Submission to the Department of Planning, Housing and Infrastructure

Application No: SSD-78268465
Project: Newington College Redevelopment (Concept and Stage 1)
[REDACTED]
[REDACTED]
Date: 29 June 2026

1. The Concordia Building

Basement Floor Plan

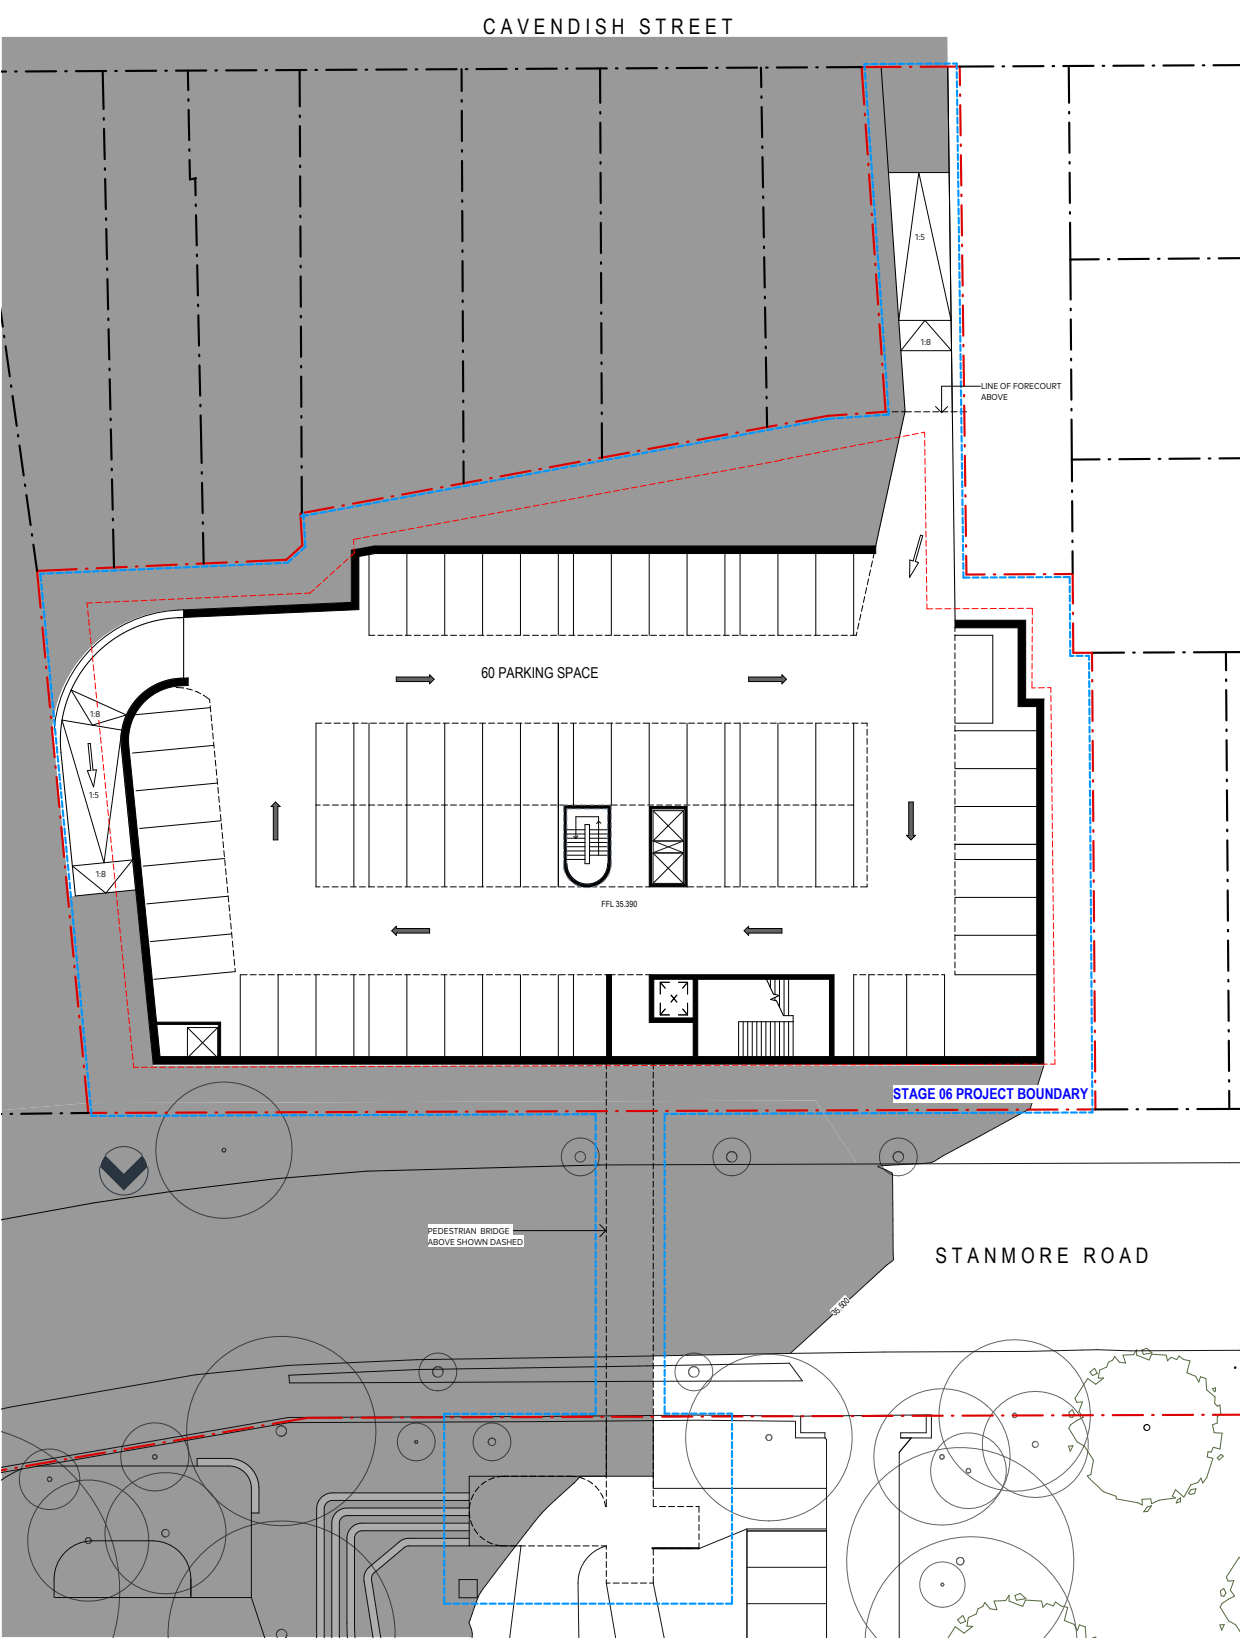
Traffic and vehicle access via Cavendish Street are a direct concern for my property. Based on the Stage 6 Concordia drawings, the proposed basement car park will provide 60 car spaces with vehicular access from Cavendish Street and egress via Stanmore Road. That means every vehicle entering the Concordia basement will do so from the residential side of the building.

Cavendish Street is a residential street. Even with exit movements directed to Stanmore Road, the entry movements, queuing, headlights, ramp noise, roller door noise, security lighting and after-hours vehicle activity would all be directed toward residential properties. This is not a minor operational detail. The Concordia building is proposed to include a performing arts

The current material does not adequately explain how these impacts will be managed for Cavendish Street residents. The issue is not whether the wider road network can accommodate the development. The issue is whether a residential street should serve as the entry point for a 60-space basement car park connected to a performing arts and event-based building.

- Confirmation of the final vehicle access and egress arrangement for the Concordia basement
- The exact location and design of the Cavendish Street entry ramp relative to  Cavendish Street
- The proposed operating hours of the Concordia basement car park
- An assessment of vehicle movements during school hours, evening events, performances and community use
- An assessment of vehicle queuing, headlight spill, ramp noise and roller door noise on Cavendish Street
- Confirmation of whether Cavendish Street will be used for drop-off, pick-up, deliveries or servicing associated with the Concordia building

Concordia - First and Second Floor Reference Plans

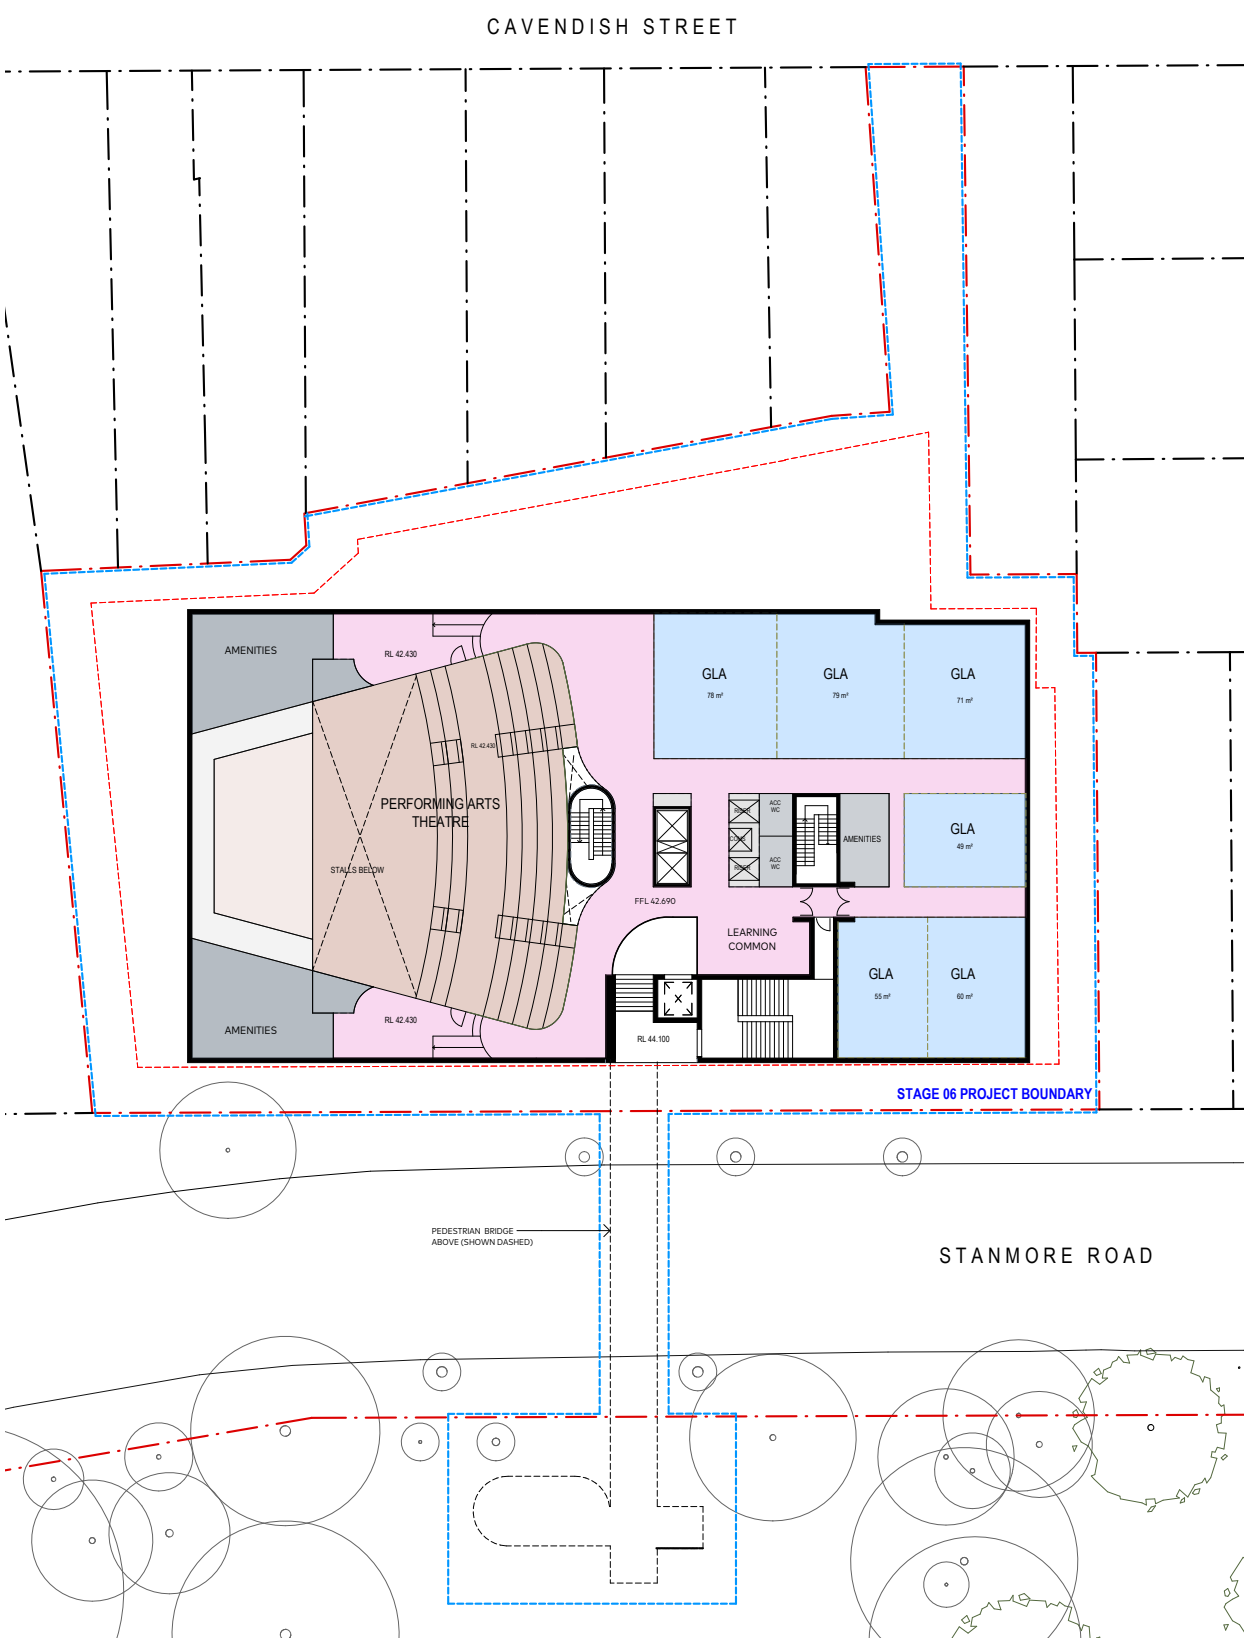
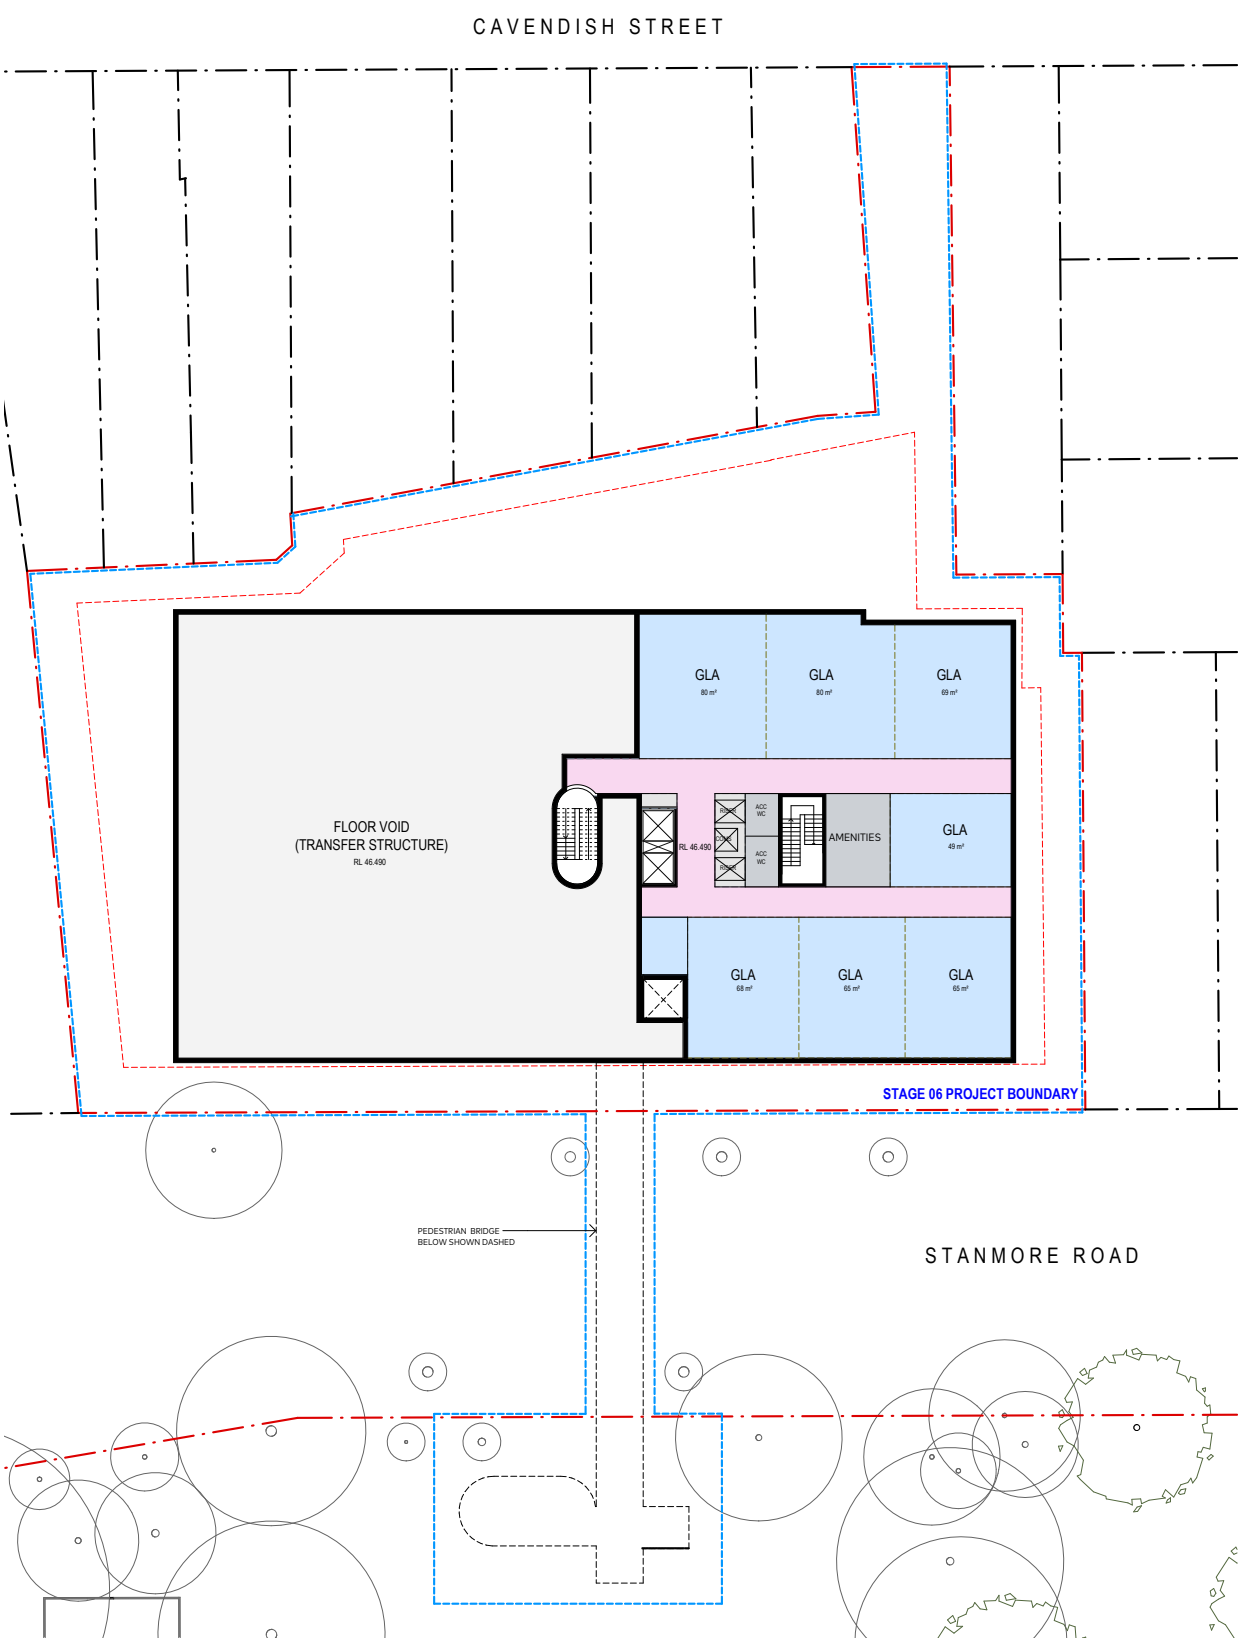
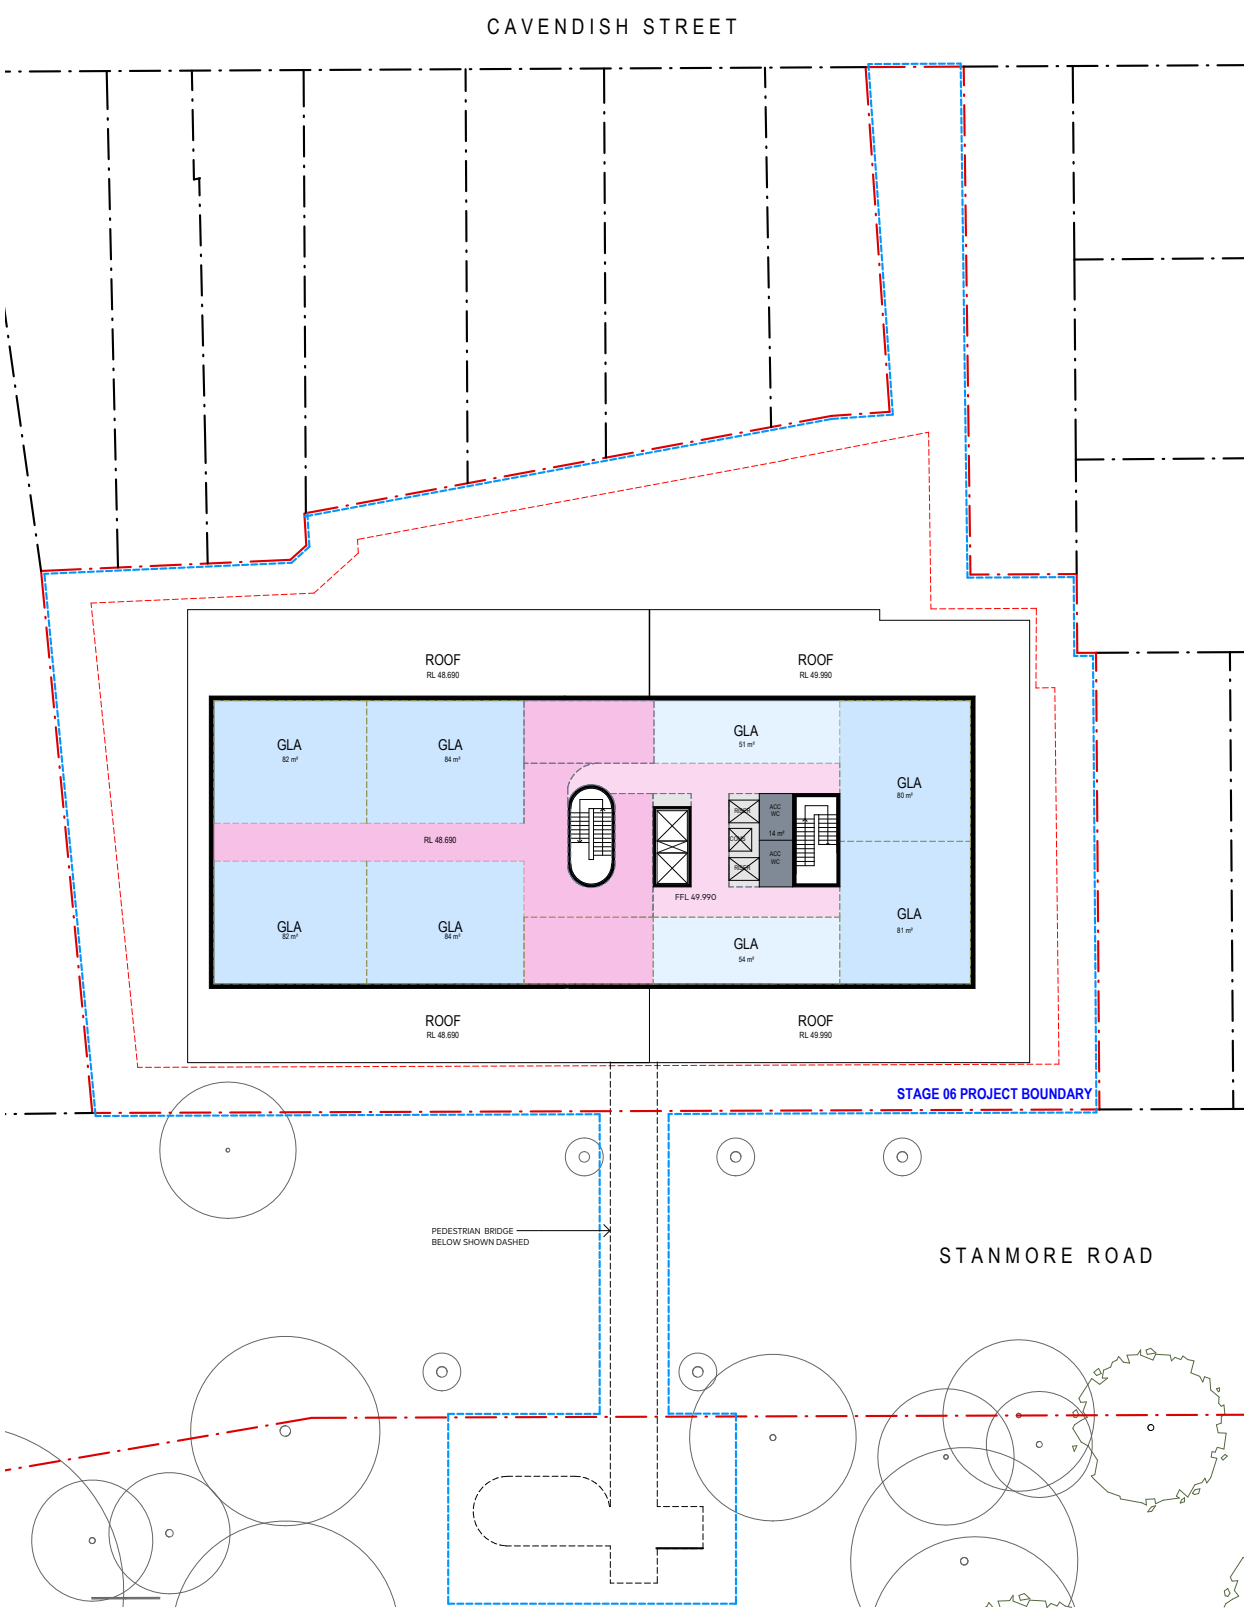
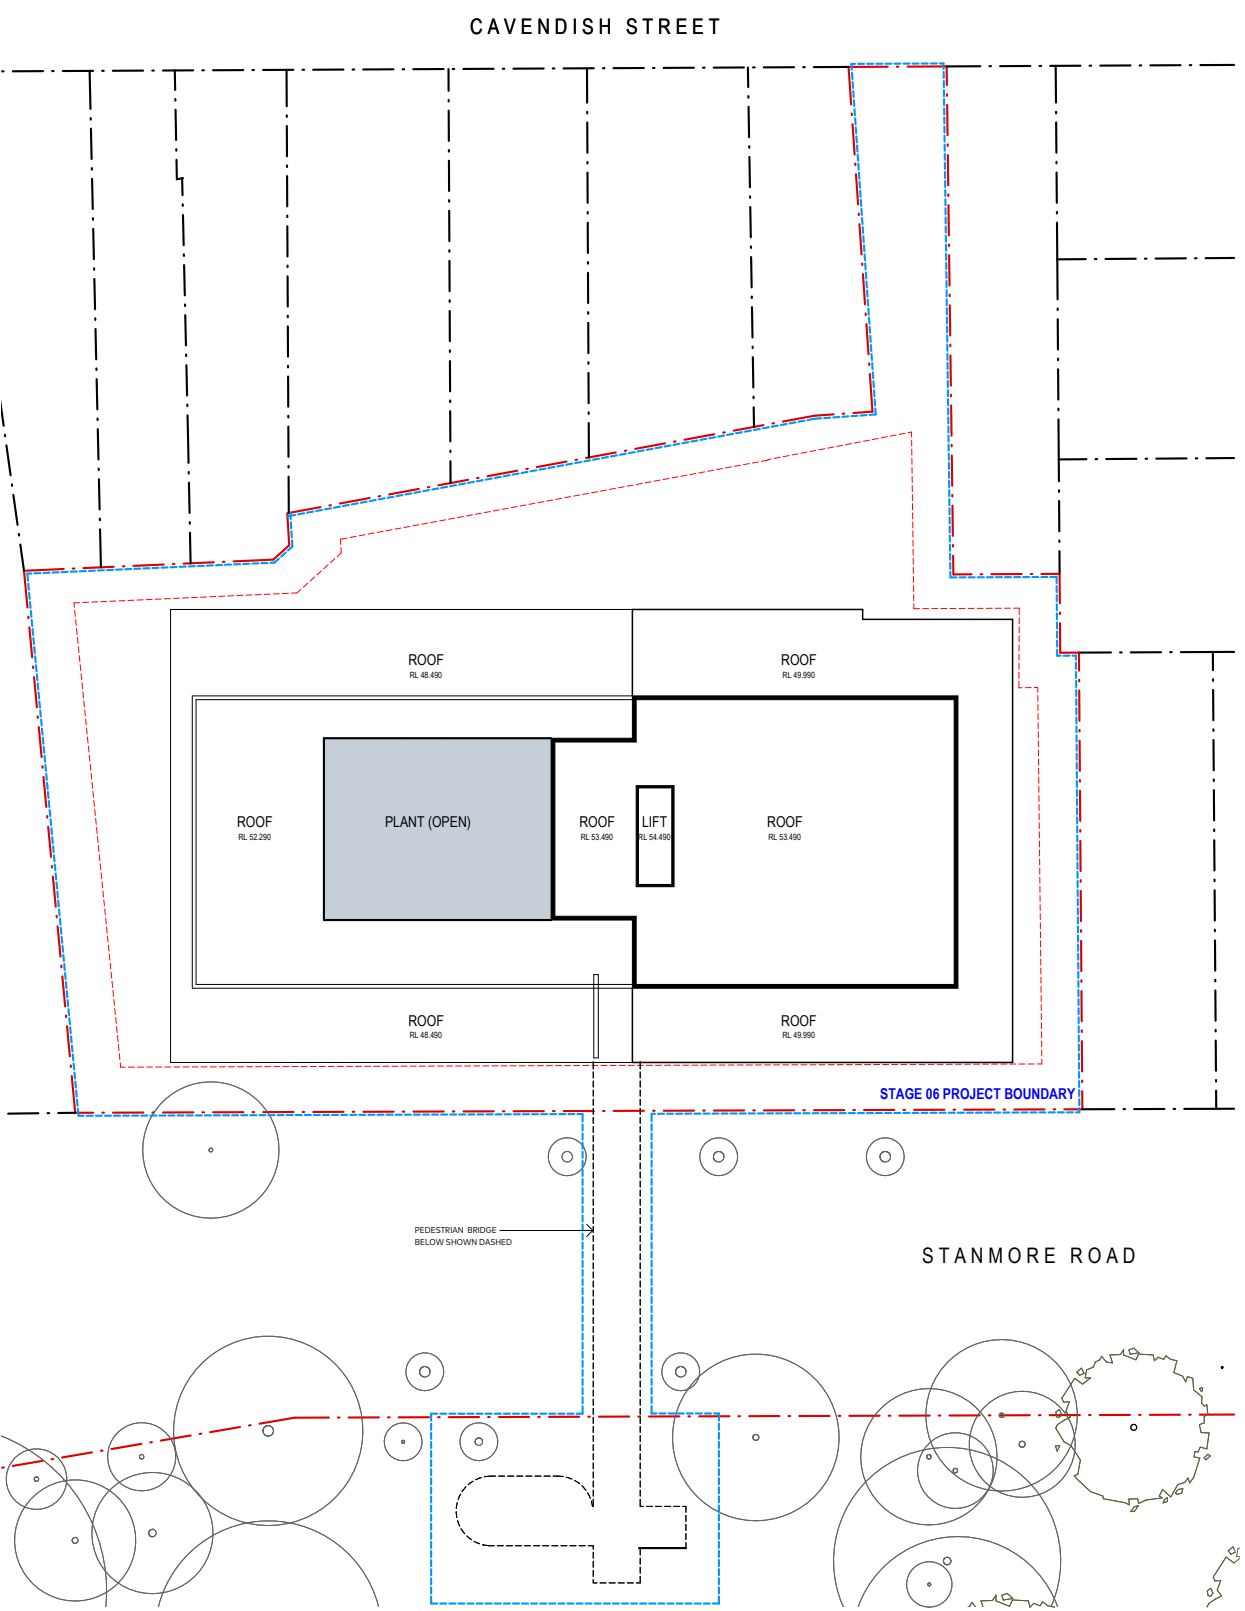
The proposed Concordia building is multilevel and sits close to the Cavendish Street residential boundary. My concern is whether upper-level windows, external walkways, stairwells and any accessible roof areas will have direct or angled views into my backyard, private open space or habitable rooms.

This is not just about roof access. Windows on upper levels facing my property are an equally important concern. If students, staff, visitors or event attendees have clear sight lines into my property from any of these areas, the impact on my privacy and day-to-day enjoyment of my home will be ongoing and unavoidable.

- Sightline diagrams from each upper level facing [REDACTED] Cavendish Street, including from windows, external walkways and stairwells
- Sightline diagrams from any roof areas, and confirmation of whether those areas are accessible and to whom
- Details of all privacy screening, louvres, high-sill windows, opaque glazing and landscaping proposed at the residential interface
- A clear statement of how overlooking of [REDACTED] Cavendish Street has been addressed in the building design
